CITY OF ALBUQUERQUE

December 22, 2020

**Re: Sandia Lab FCU
1100 Rio Grande Blvd NW
Traffic Circulation Layout
Engineer's Stamp Date 12-15-2020 (H13-D109)**

ENGINEER'S SEAL RONALD R. BOHANNAN P.E. #7868	SANDIA LAB FCU RIO GRANDE + 1-40	DRAWN BY RG
	TRAFFIC CIRCULATION LAYOUT	DATE 10-8-2020
	TERRA WEST, LLC 5571 MIDWAY PARK PL NE ALBUQUERQUE, NEW MEXICO 87109 (505) 858-3100 www.tierrawestllc.com	DRAWING 2012100-SP
		SHEET # C1
		JOB # 2012100

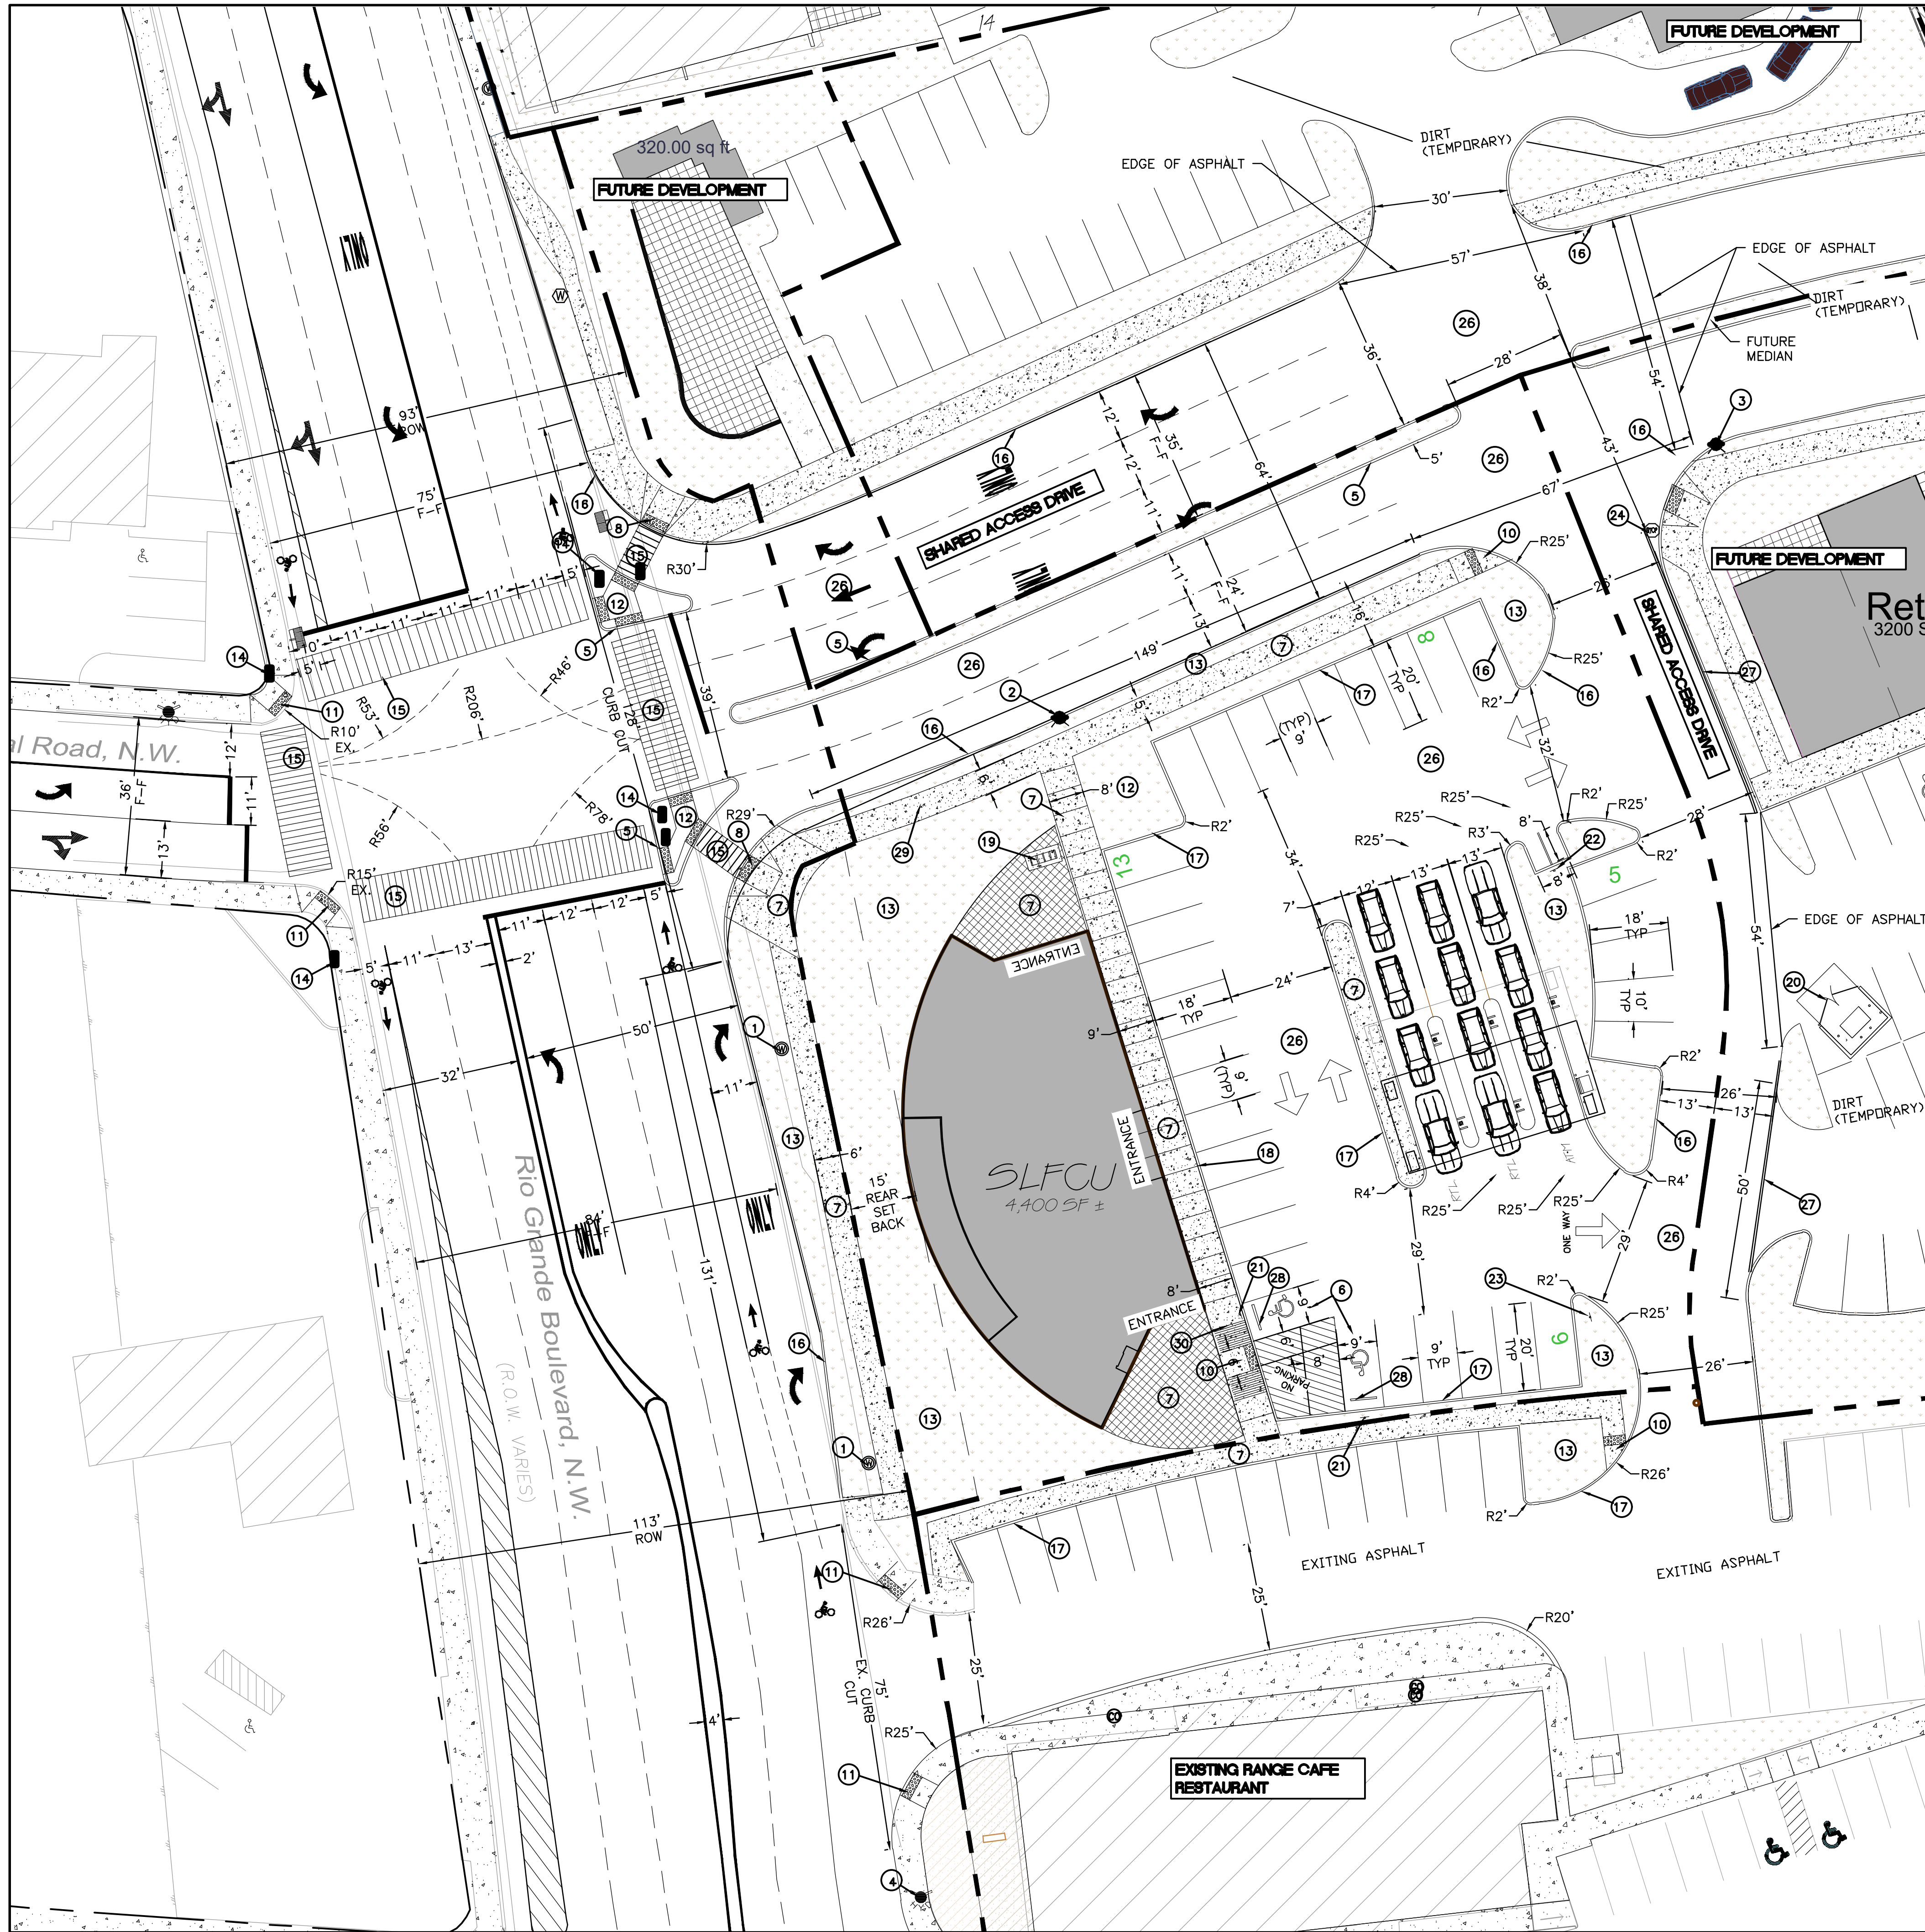
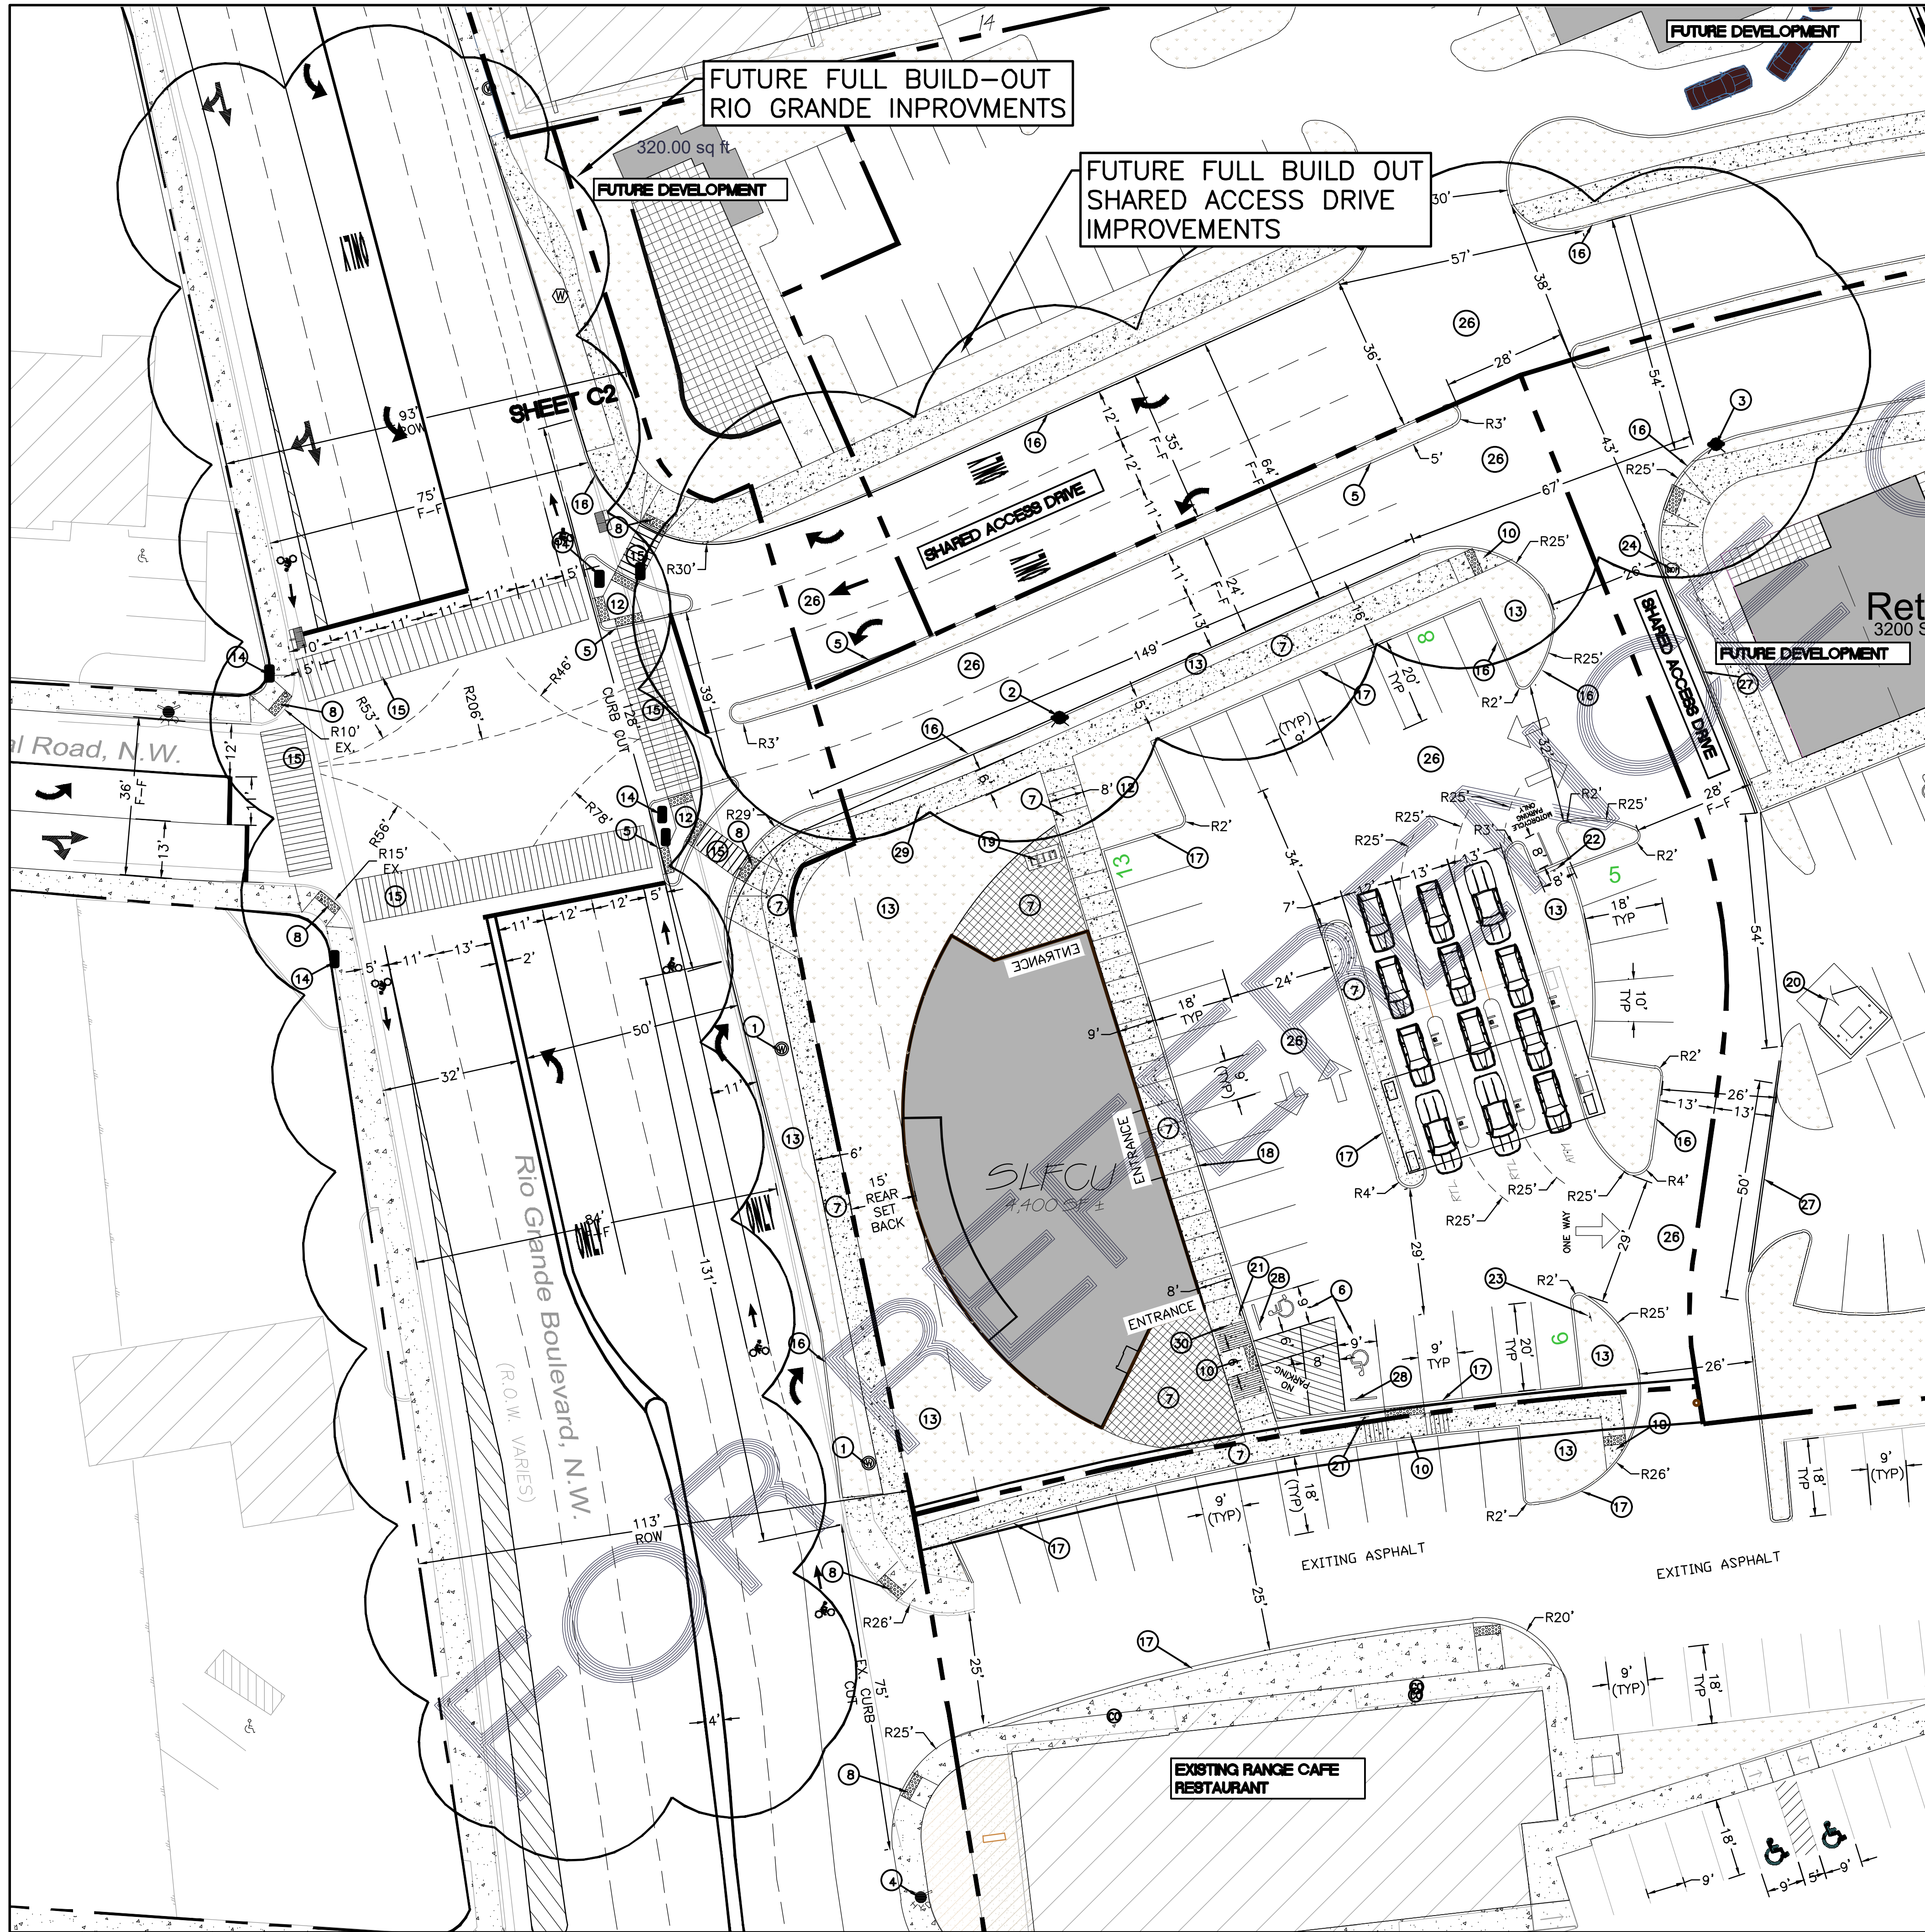
3. The curb ramps that are south of the proposed building are not lined up across the parking aisle.
4. A Traffic Study evaluating the alternative of a roundabout versus a traffic signal is needed at the Florence intersection. The type of traffic control at the intersection should be decided and agreed upon by all stakeholders prior to platting action. All improvements within the right-of-way should be built per work order and placed onto an infrastructure list.
